Subject: RE: BE/20/22/DOC

Condition 4 – Lighting

Drawing Title:
**ELECTRICAL SERVICES
EXTERNAL LIGHTING LAYOUT**

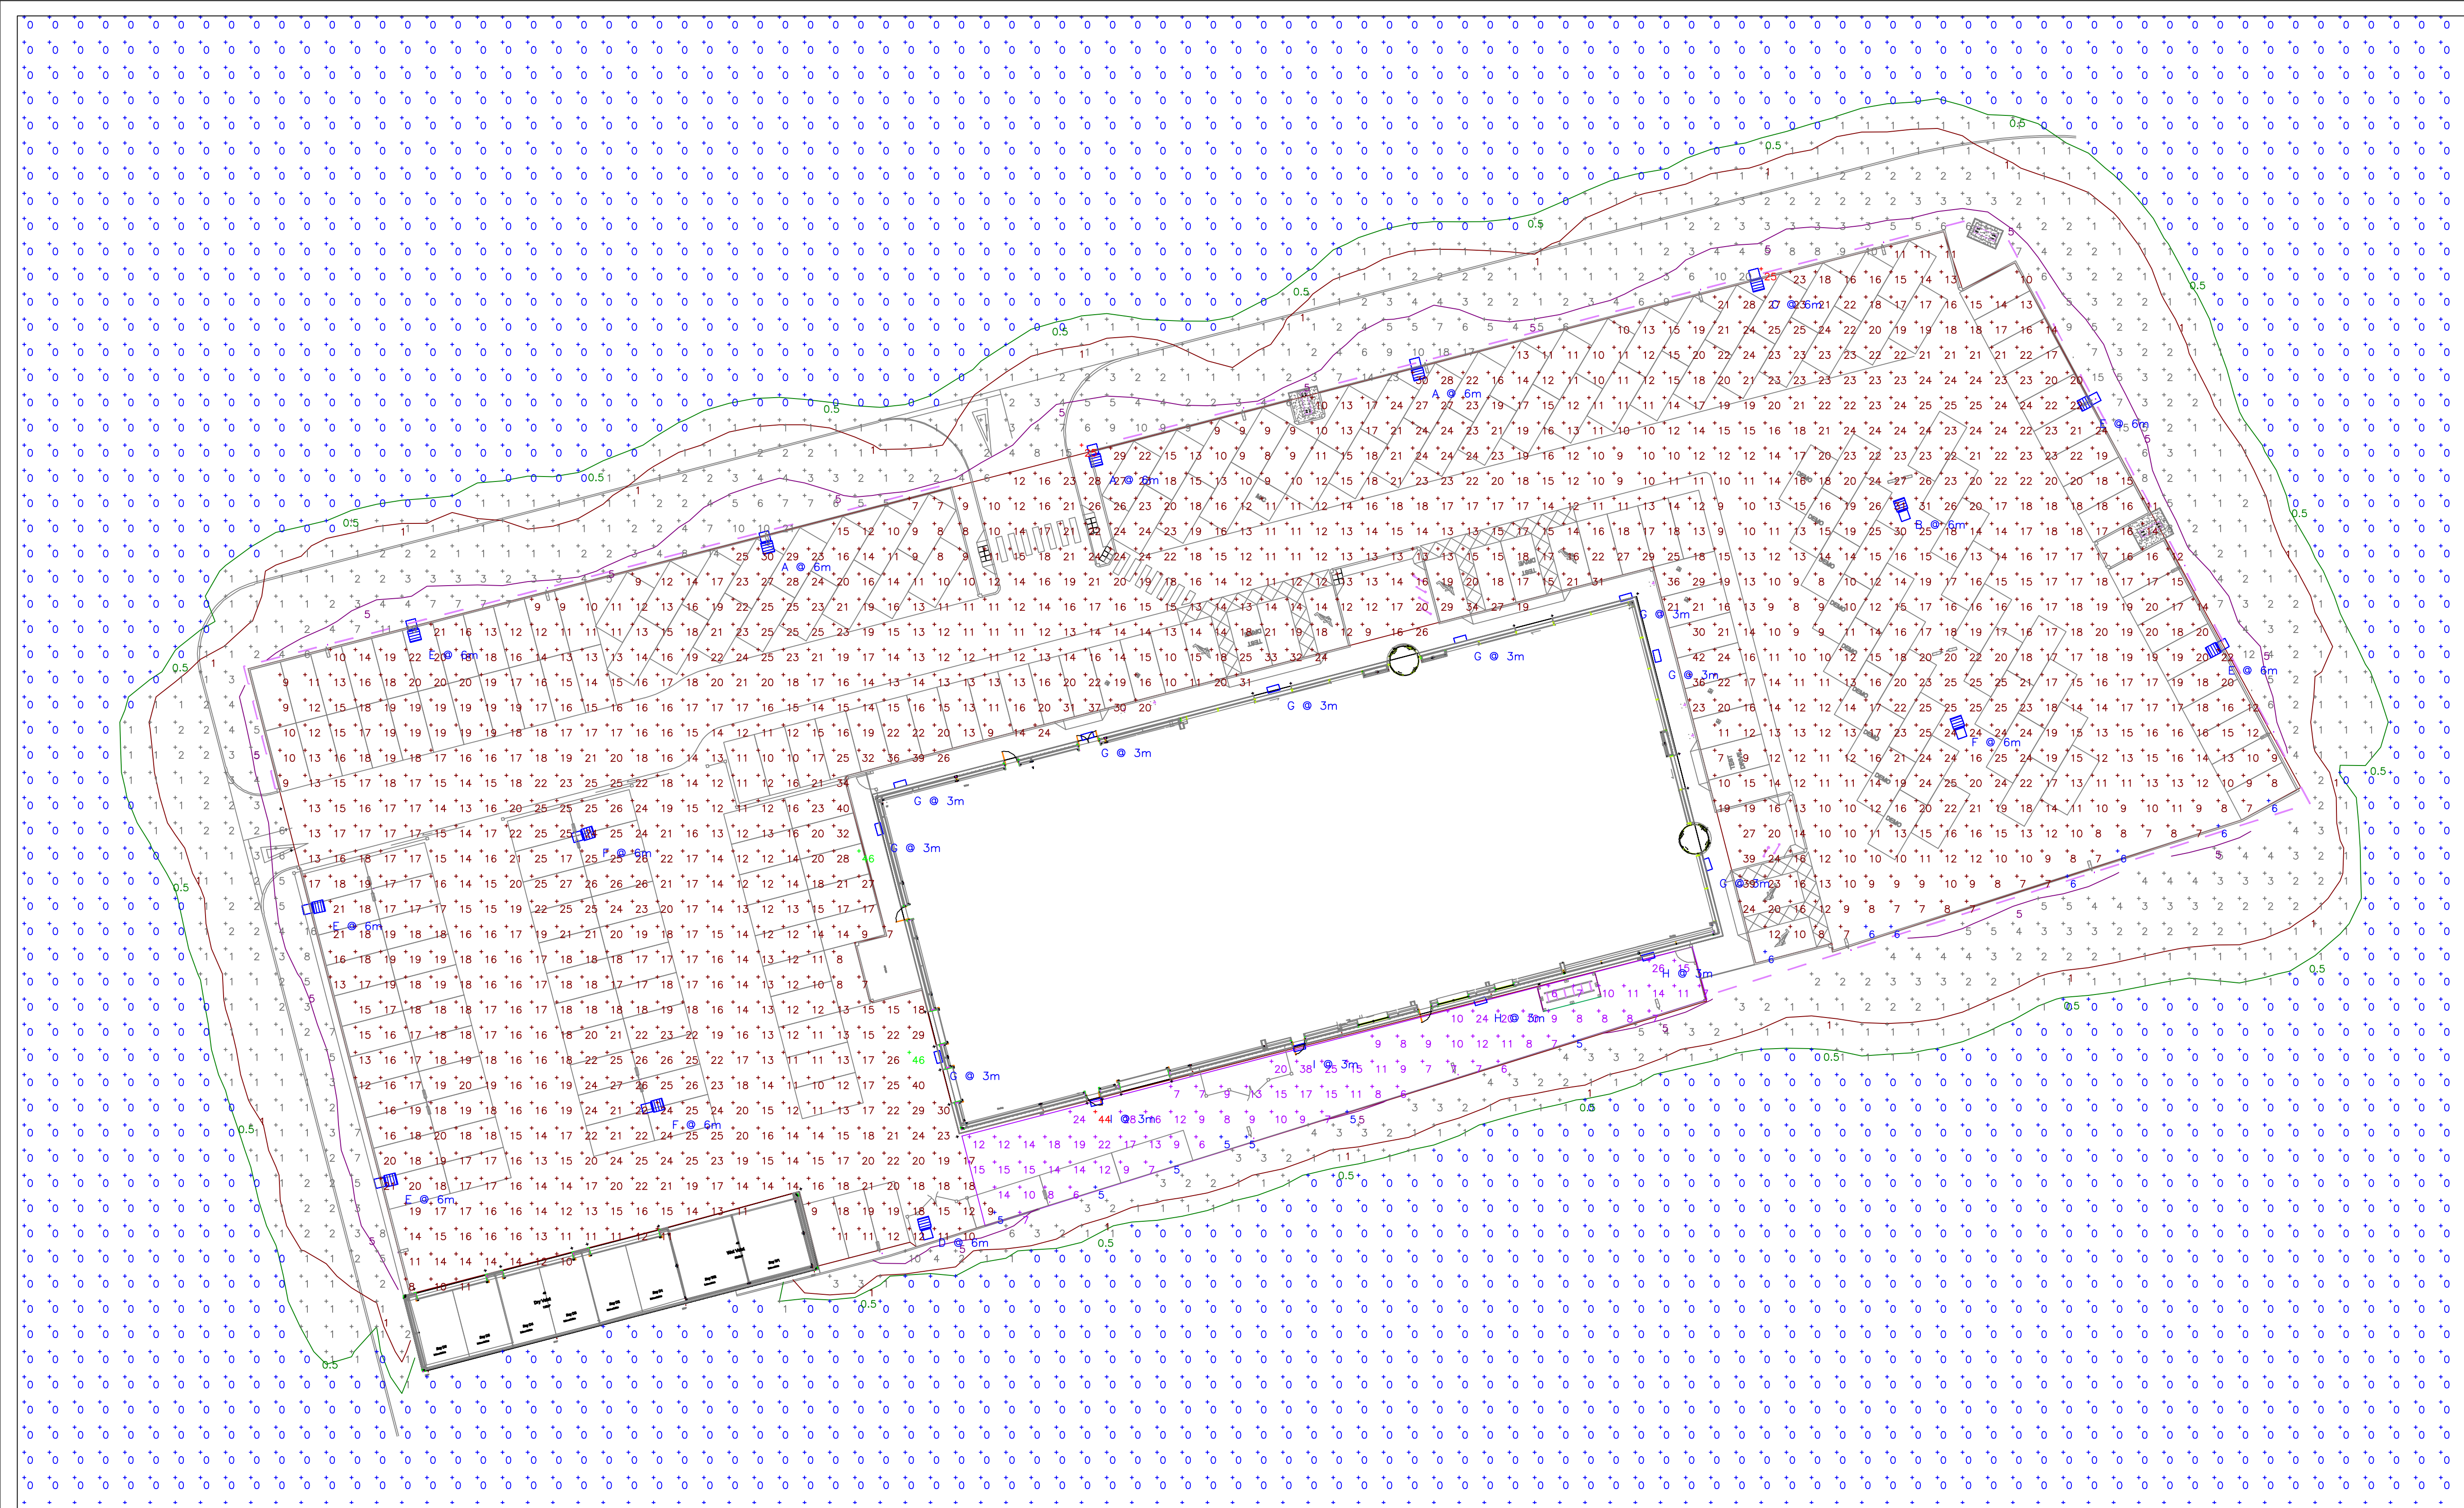
1. Please could the applicant confirm whether or not they have referred to (ILE) Guidance Note 1 for the reduction of obtrusive light 2021 as this does not appear to be stated in the Relevant Standards and Guidance section?
2. The document alludes to the fact that the scheme is consistent with Zone E2 but does not directly state it (last 2 paragraphs on page 5). Please could the applicant confirm whether or not the scheme complies with Zone E2 or not?

Thank you for your email; we have updated the report (attached) to incorporate the comments and can confirm the following:

- The external lighting has been designed to ensure the reduction of obtrusive light is maintained across the site. This has now been added to the Relevant Standards and Guidance section.
- We can confirm that the external lighting has been designed to comply with Zone E2.
